Ribble Valley Borough Council
Council Offices
Church Walk,
Clitheroe
Lancashire
BB7 2RA

Phone: 0300 123 6780
Email: developeras@lancashire.gov.uk
Your ref: 3/2025/0401
Our ref: 3/2025/0401/HDC/KW
Date: 10 June 2025

Location: Buckley Dene Preston Road Ribchester PR3 3YD
Proposal: Replacement dwelling
Grid Ref: 363555 436769

ground floor plan

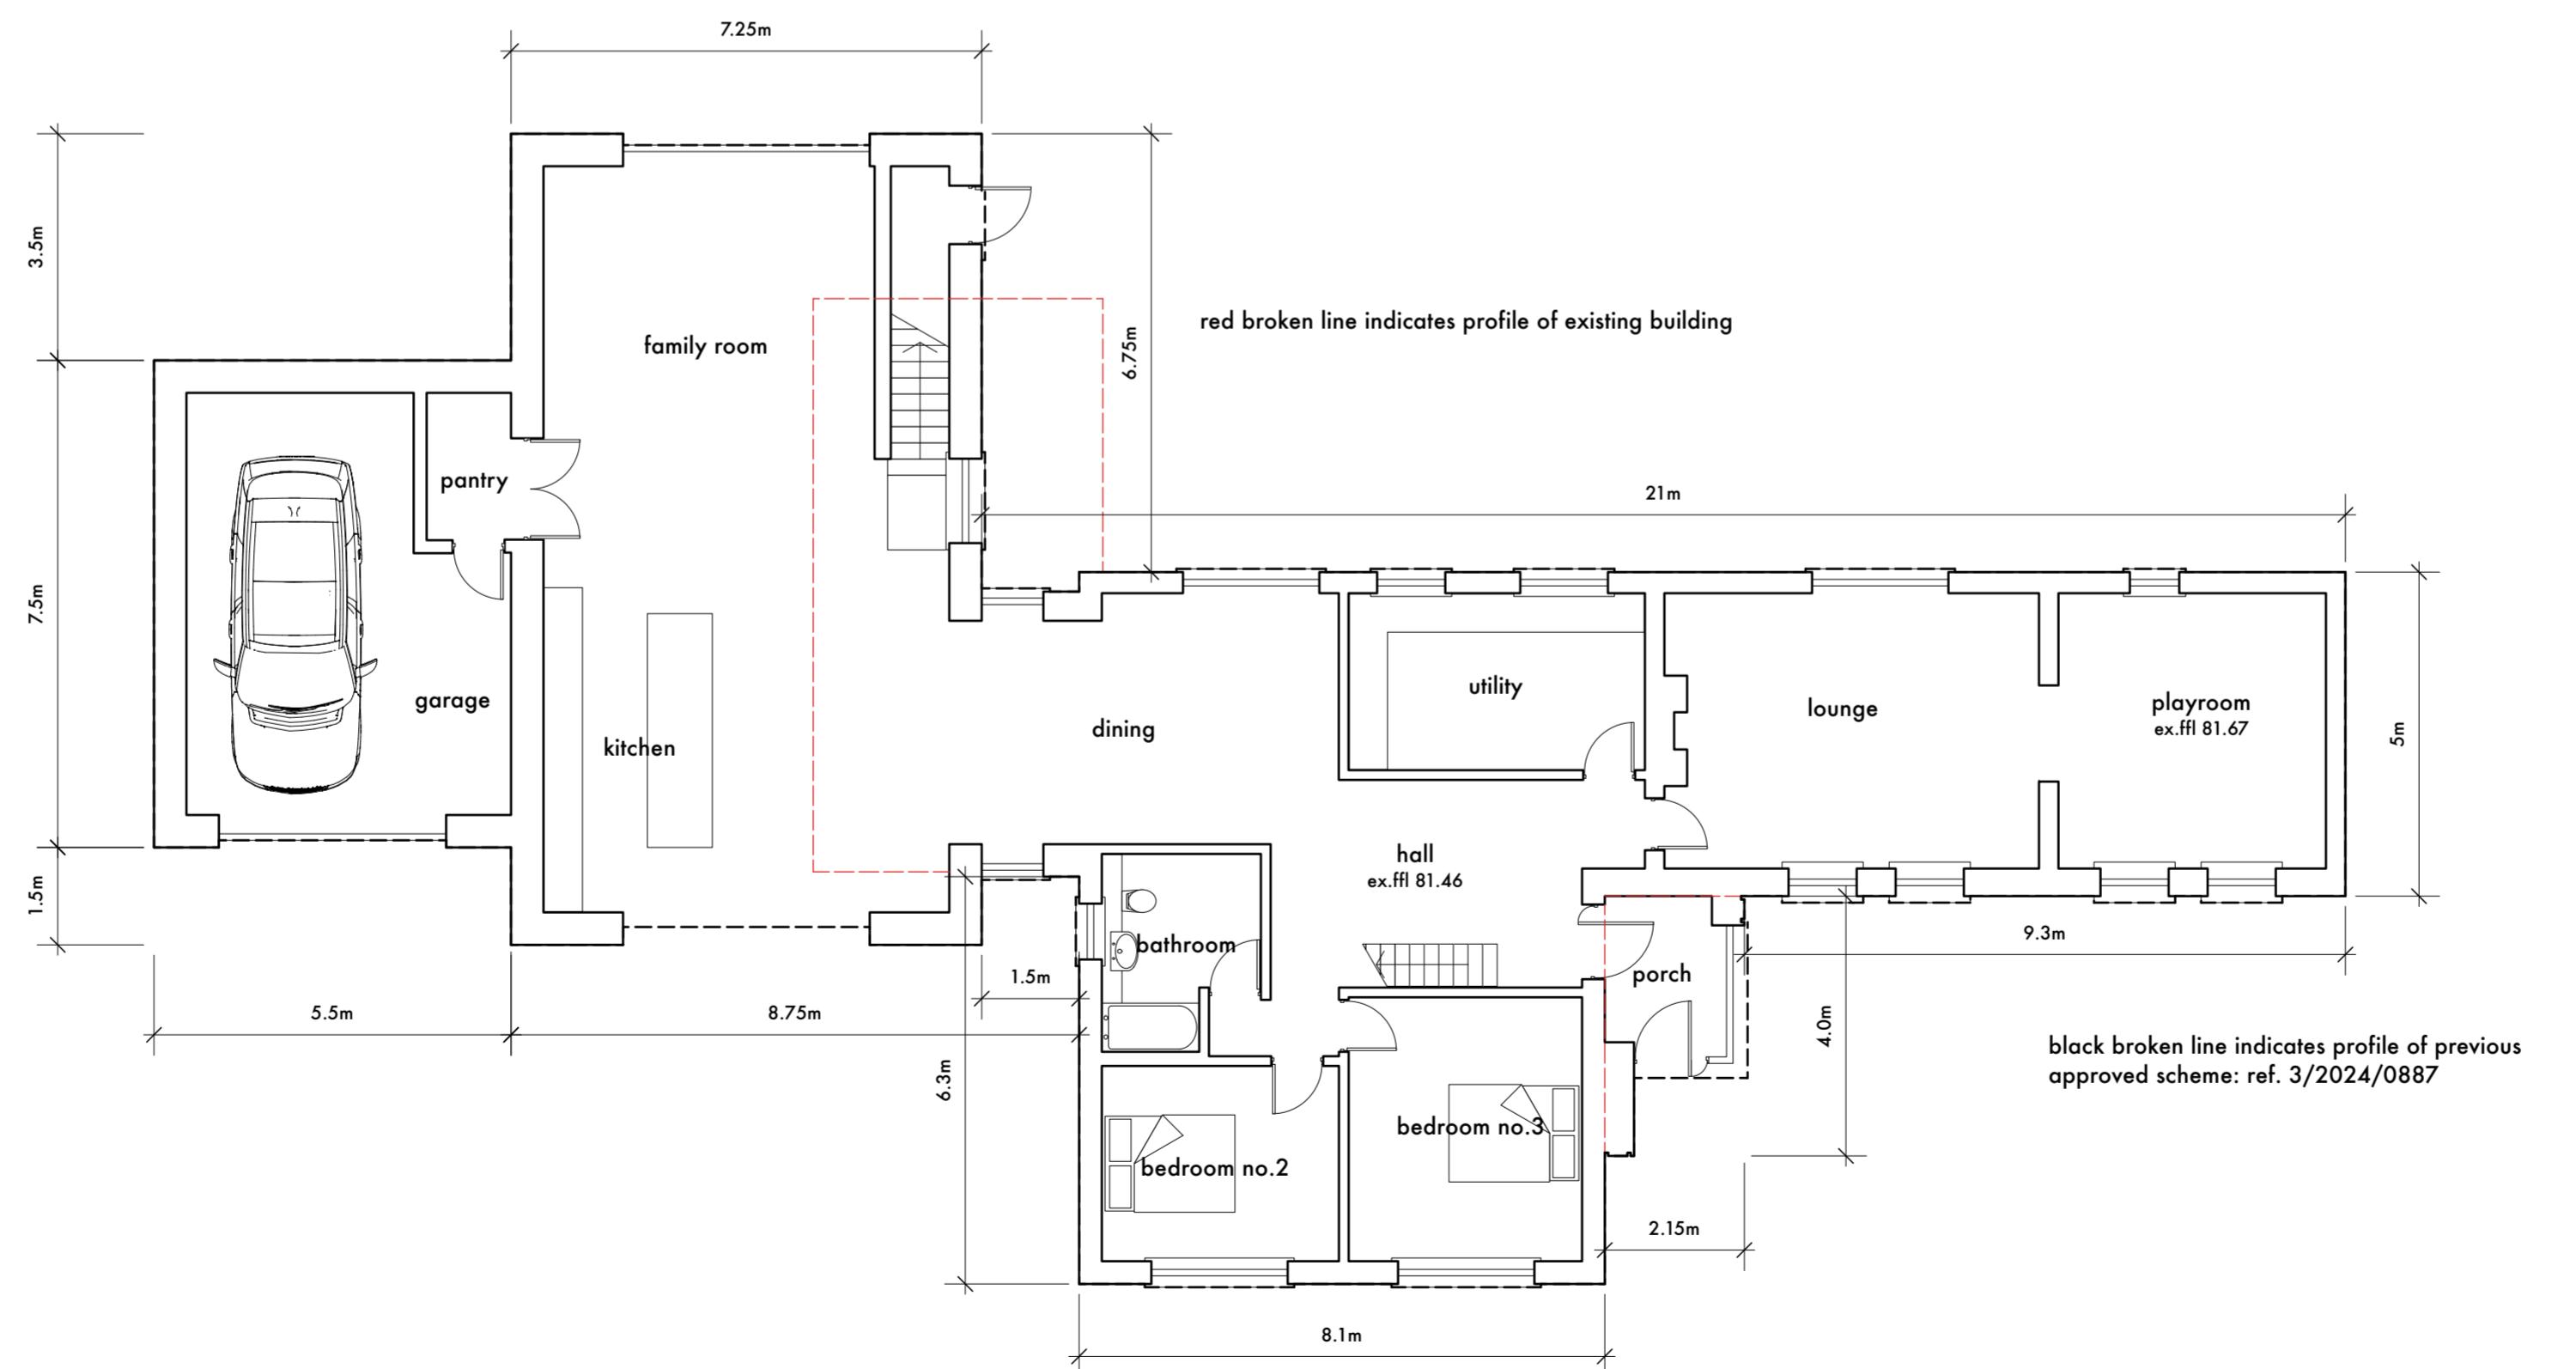
The LHA note that an integrated garage is proposed as part of the development. The recommended minimum internal dimensions for a single garage size is 6m in length and 3m wide. The recommended distance of 6m is based on the length of a large family car (Ford Mondeo Estate 4.58m long), clearance at the rear of the car (200mm), overhang of the garage door (600mm) and room to stand in front of the car and open/close the garage door (600mm). As the garage meets the recommended minimum internal dimensions, it can be considered acceptable for parking provisions.

drawing number
PL.01

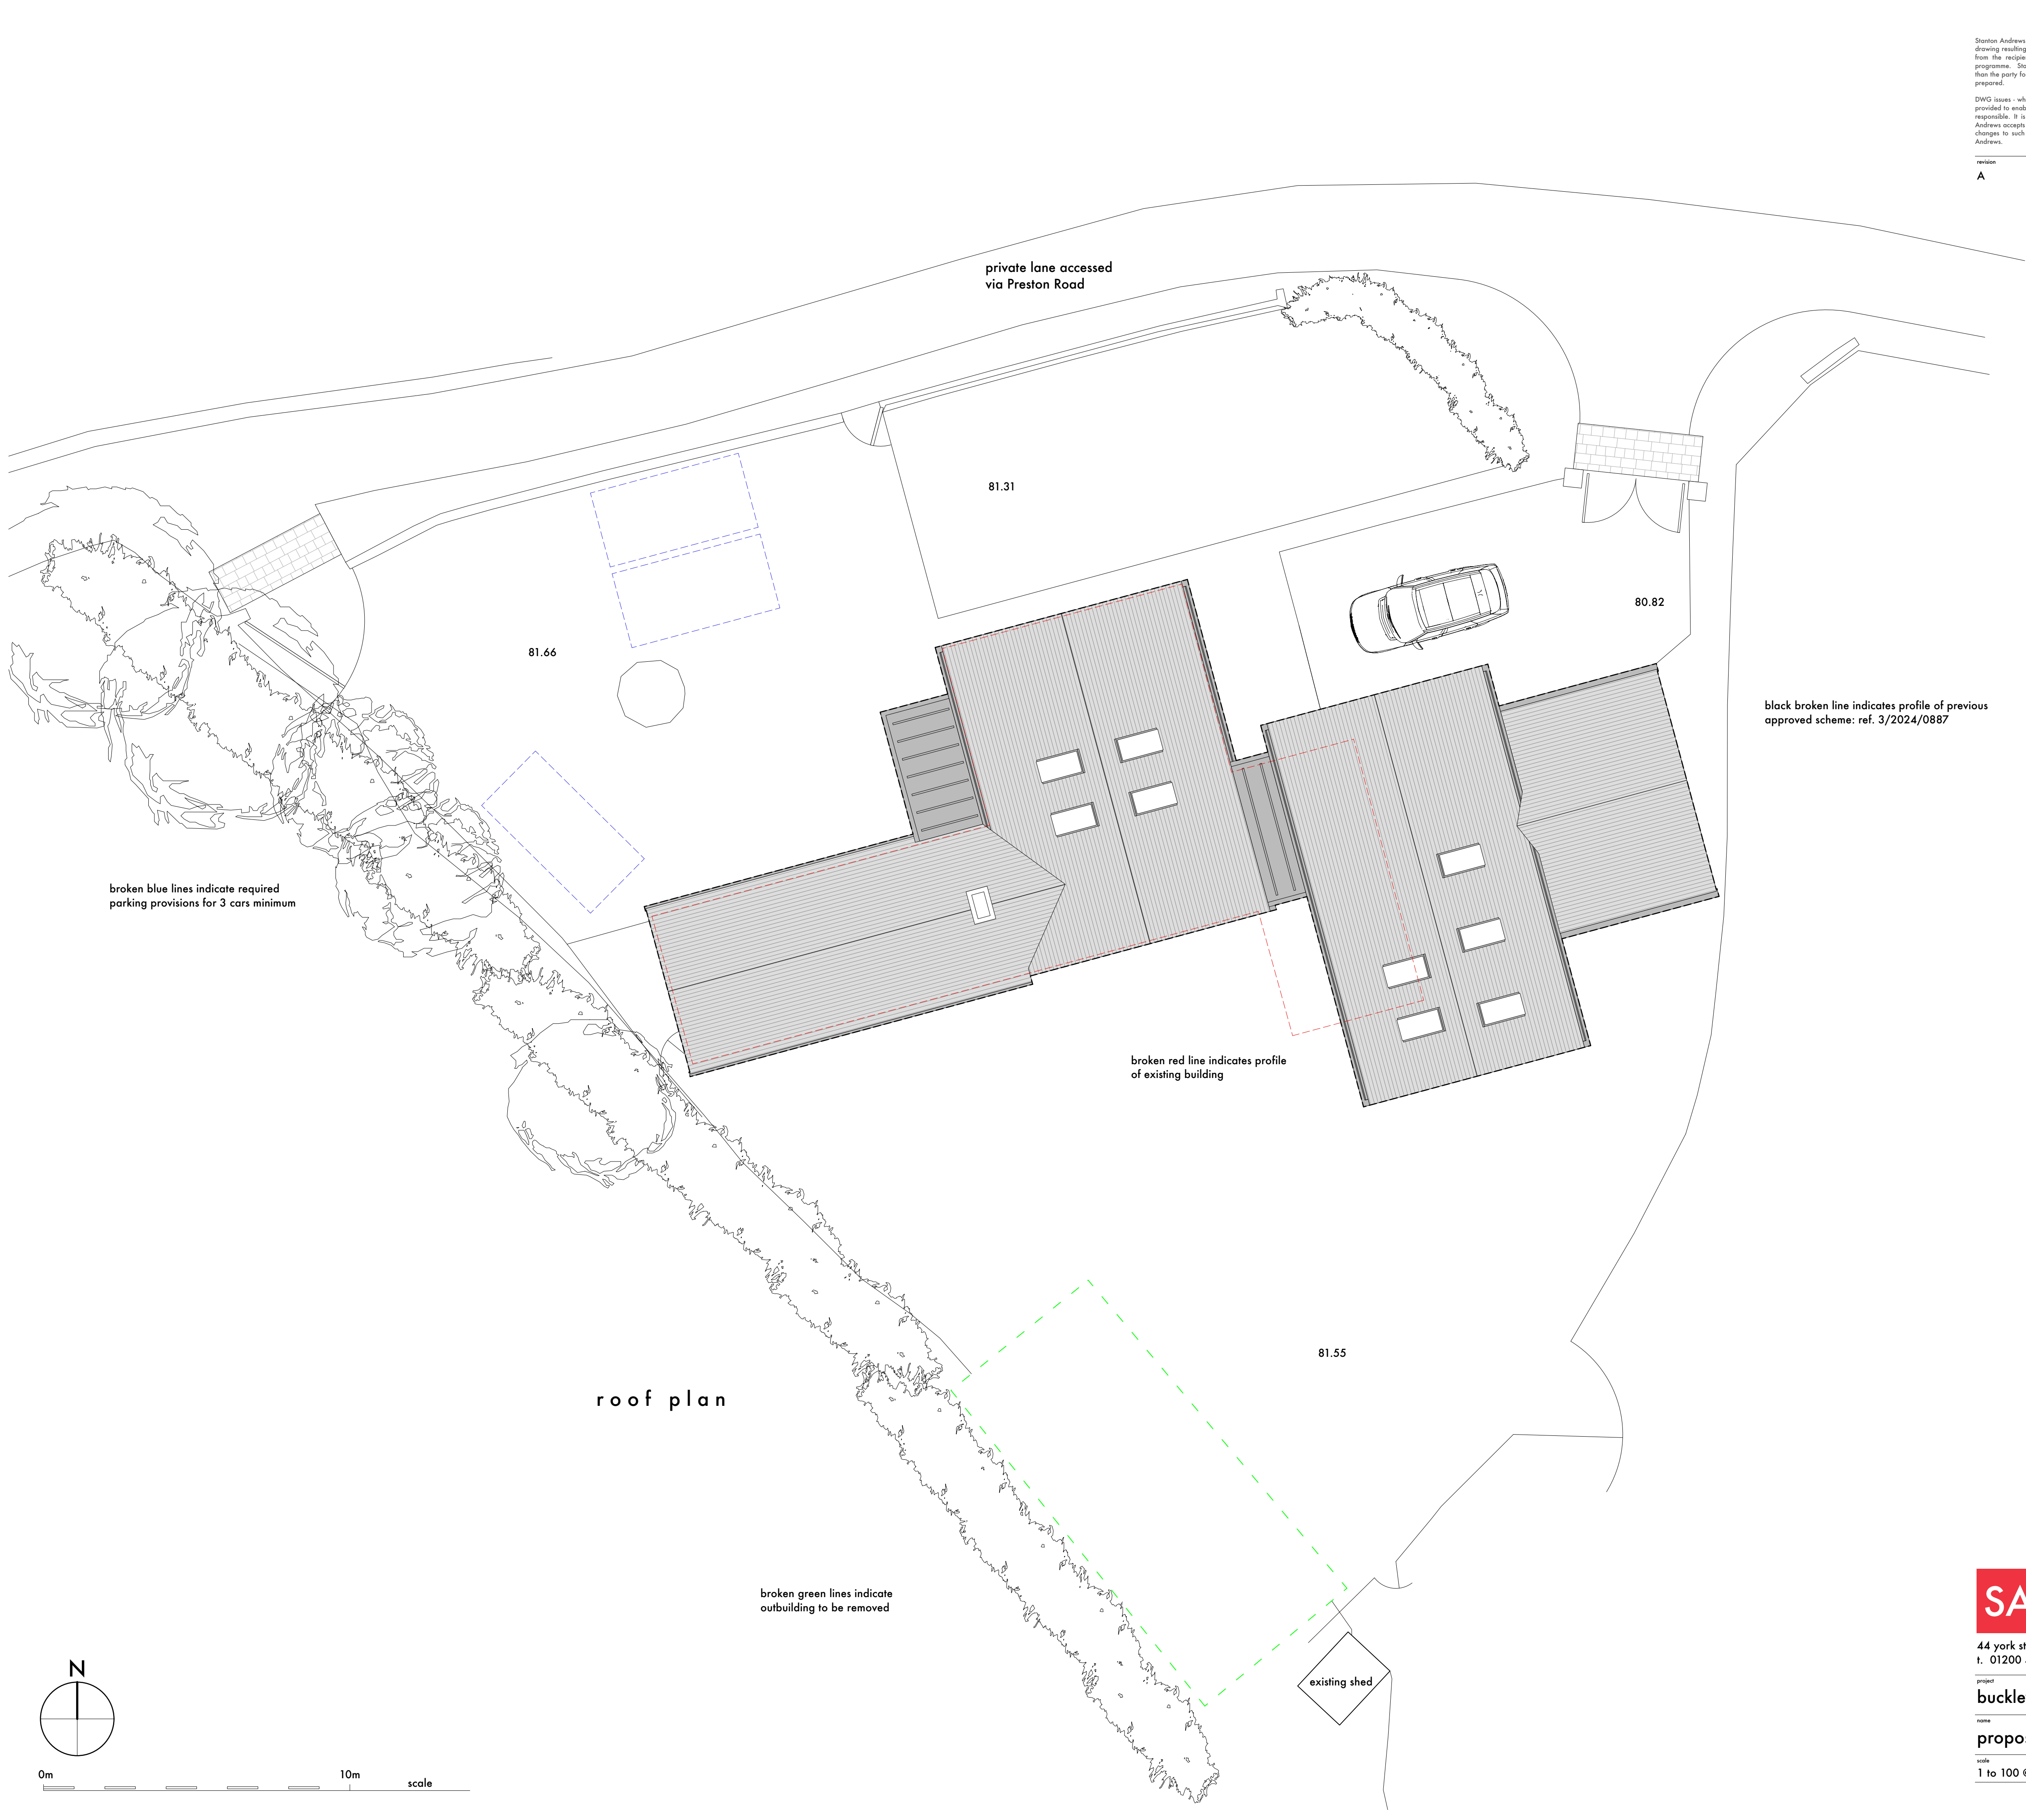
The LHA have reviewed the proposed site plan drawing number PL.01 Revision A and are aware that the dwelling complies with the LHAs parking standards as defined in the Joint Lancashire Structure Plan. Therefore, the LHA have no objection to the proposal.

1. The development hereby permitted shall not be brought into use until the car parking and turning areas shown on the approved plan(s) have been provided in full and are available for use. The car parking and turning areas shall thereafter be kept available for the parking and manoeuvring of vehicles at all times.

2. Secure covered cycle storage suitable for 2 bicycles shall be provided within the development.
